STORE PROPERTY INVESTMENTS LTD
LAND WEST OF BROOK LANE AND
SOUTH OF A259
RUSTINGTON

ROAD SAFETY AUDIT RESPONSE
REPORT
STAGE 1 - ROAD SAFETY AUDIT

JUNE 2018

drawing number SPRUST(BROOK LANE).1/10 rev. D

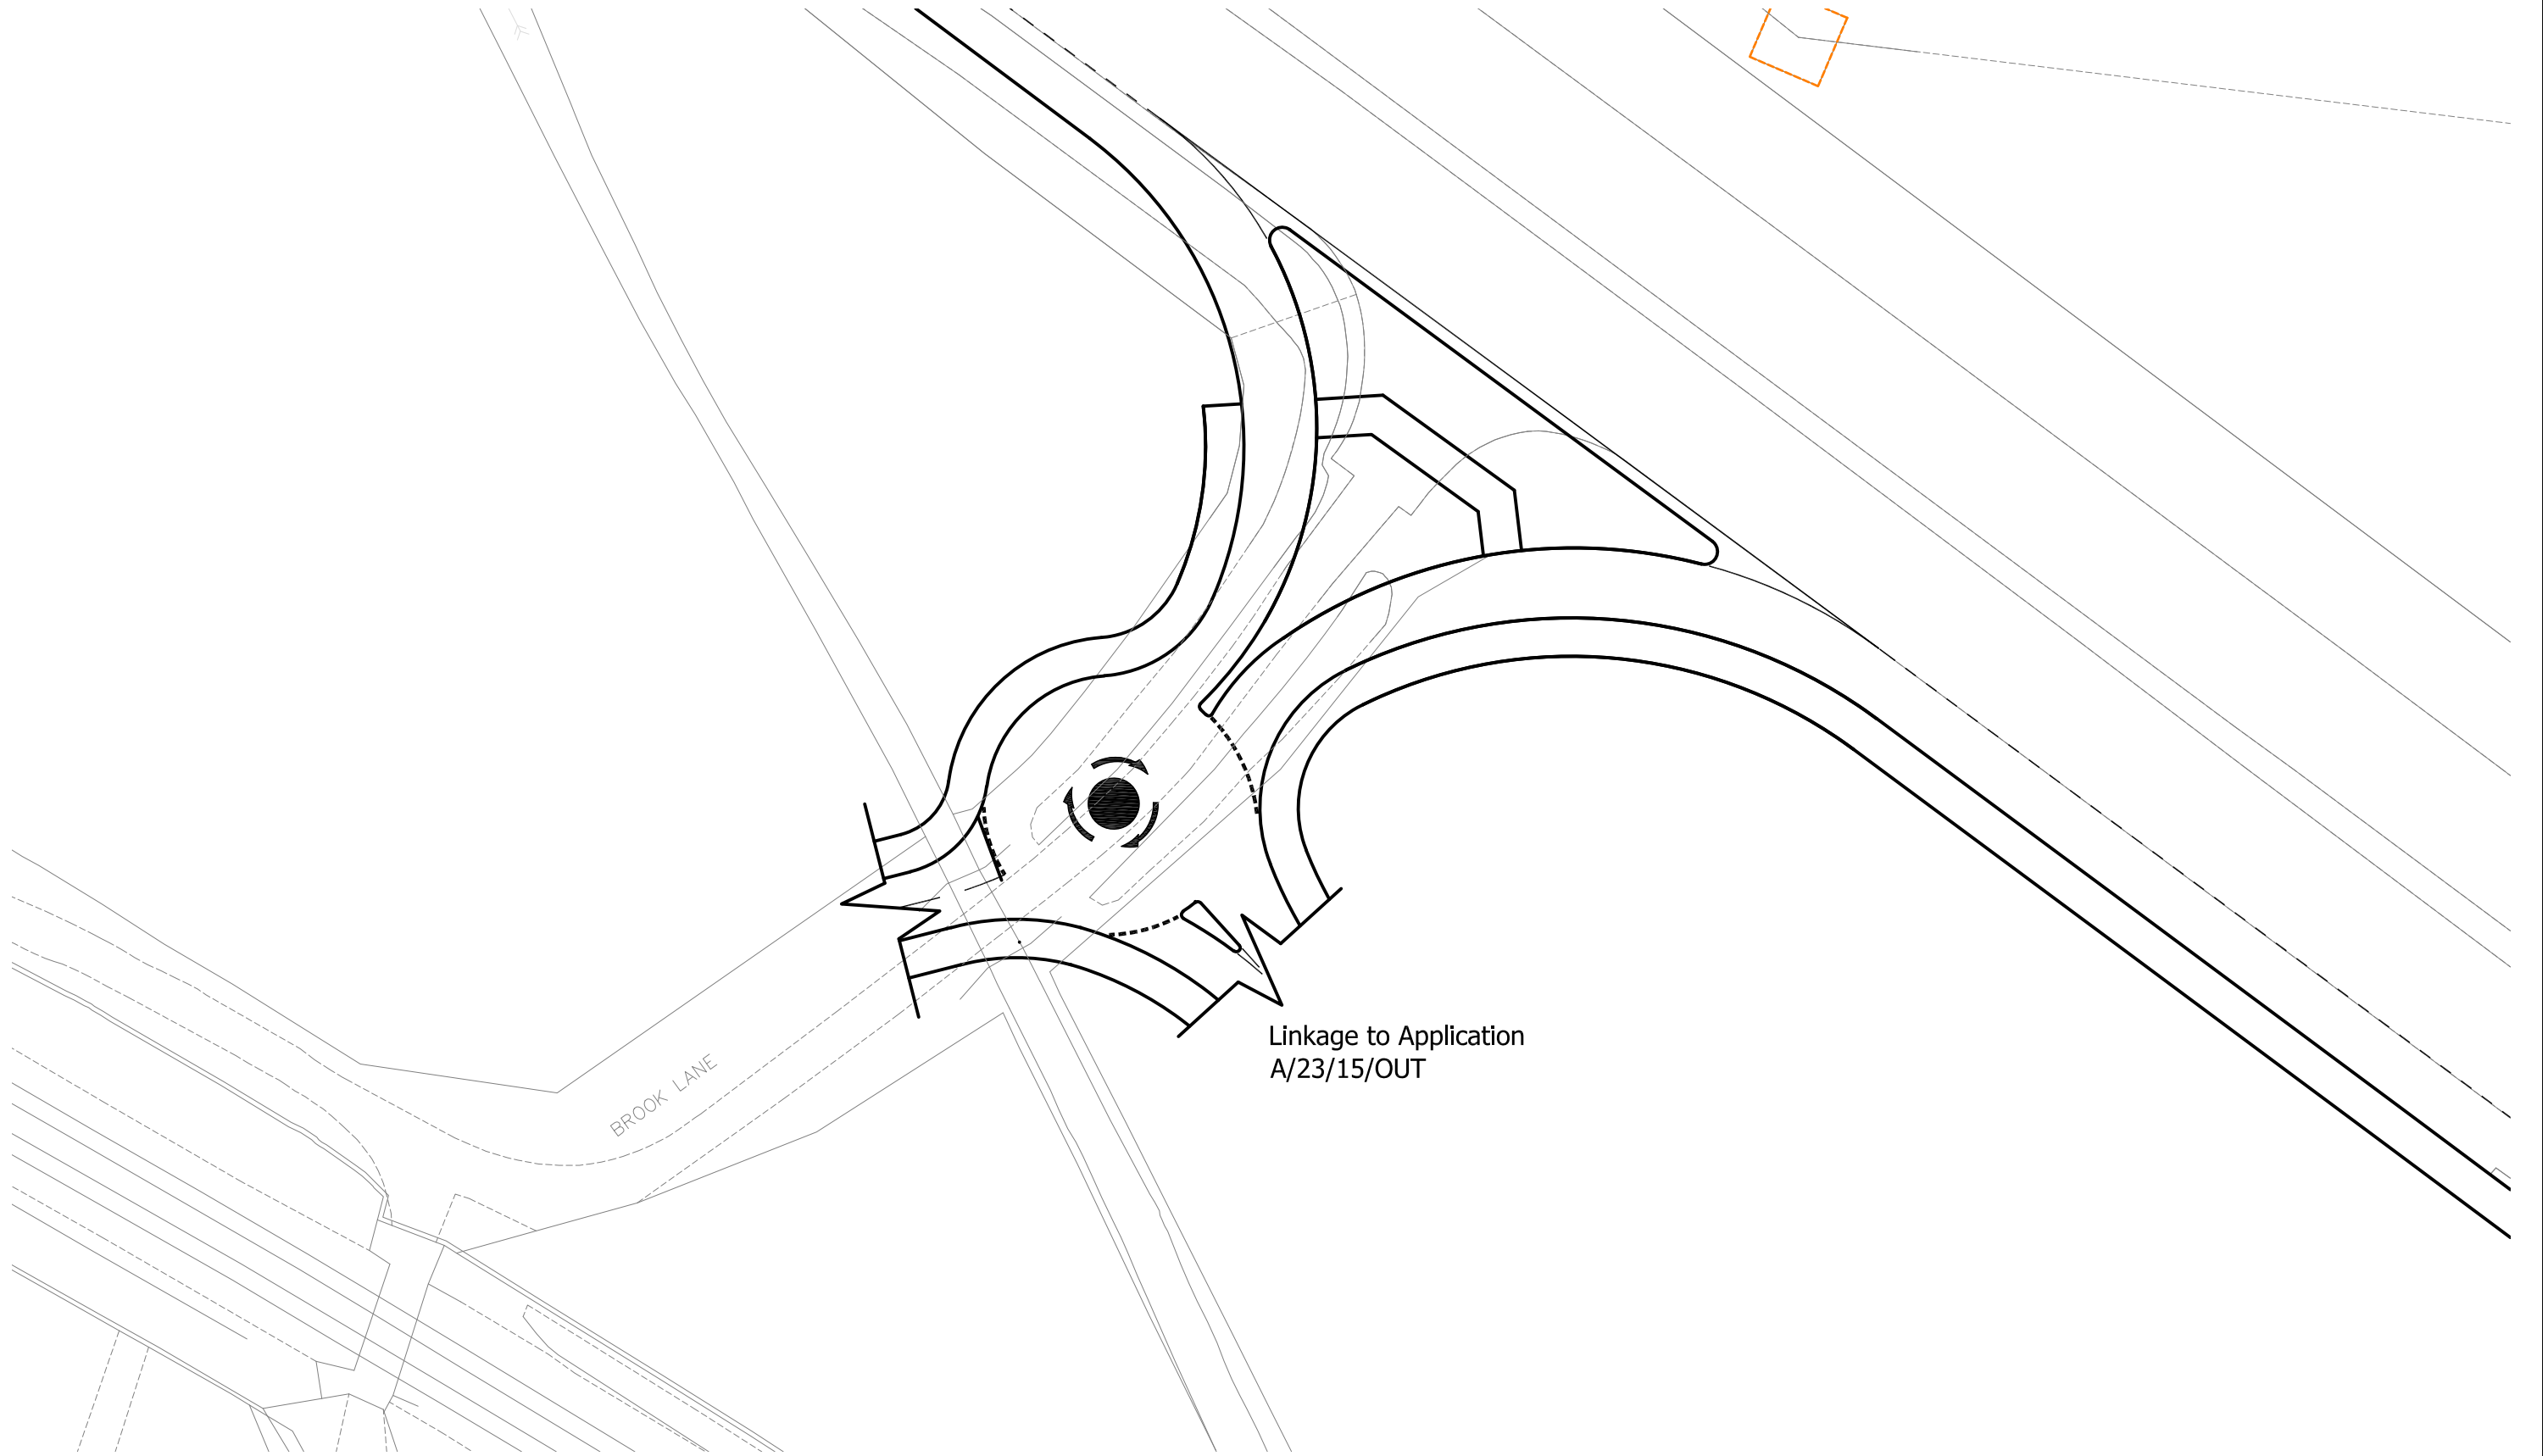
Location: Proposed central island

Summary: Margin omitted

The westbound approach on the A259 to the proposed junction is provided with a margin (circa 1 metre), is delineated by a solid white line. The proposed northern kerb line of the proposed traffic island does not benefit from a margin. This could result in vehicles striking the kerb and subsequently losing control.

Offset the northern kerb line southwards to provide an appropriate margin.

This is agreed, drawing SPRUST(BROOKLANE).1/10B included at **Appendix D** shows a revised kerb line to include a 1m margin.
